Dr. South's C.E. Primary School
Bletchington Road, Islip, Kidlington, Oxon OX5 2TQ
Faith, Hope and Love

Planning Application Ref. 14/00204/DISC: consultation response and pre-action letter under the protocol for judicial review

Figure 2.1 *Modelled School Building*

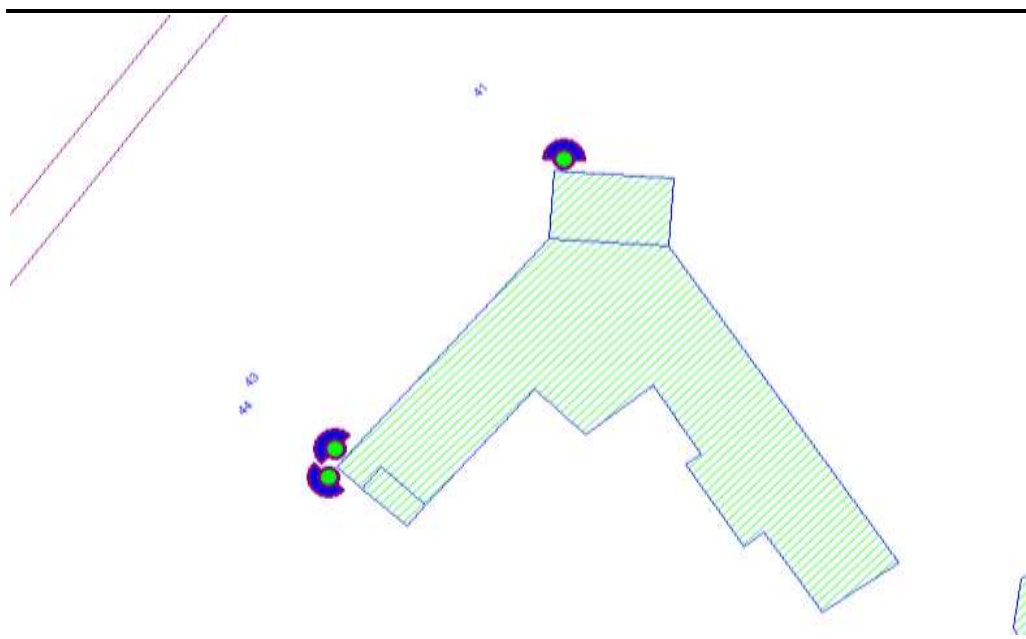
14. We understand that the Promoter contends that they did appropriately model for the physical premises of Dr. South’s. Their supplementary information provides daytime (only) L_{Aeq} estimates of noise impact on three receptor points on the school building. However, they have not addressed the points raised in our letter of 7 October 2014 regarding the requirements placed on them – and accepted through their own stated policy – to take particular account of the needs of Dr South’s as an educational establishment. That appears to us to be a material oversight of a highly relevant consideration

16. Furthermore, the Promoter has failed in any way through its noise and vibration mitigation scheme to deal with its own policy regarding outdoor lessons in summertime. This is evident from the fact that it has not taken or estimated readings for the outdoor premises of Dr. South’s but only estimated for receptors on the school building. We therefore have only the Promoter’s noise contour map to work from, which certainly suggests that the noise impacts will be greater in the play and outdoor areas closer to the railway than the school buildings. This is of particular concern to us given the physical limitations of Dr. South’s site which constrains the range of locations for outdoor teaching. We are also concerned that the location of the play equipment in the playground is adjacent to the railbridge and therefore that there is a material risk that, when maximum noise is experienced, children will be unable to hear

- i. A detailed survey of the school grounds was not carried out and we have reason to believe that the Promoter has not visited the site of Dr. South's to inform itself about the school's situation. In the supplementary analysis, the Promoter's agents state their analysis "has been based on inspection of imagery taken from the road." Furthermore, they state they are unaware whether or not a new building has been built (it has; and has been in use since January 2015).
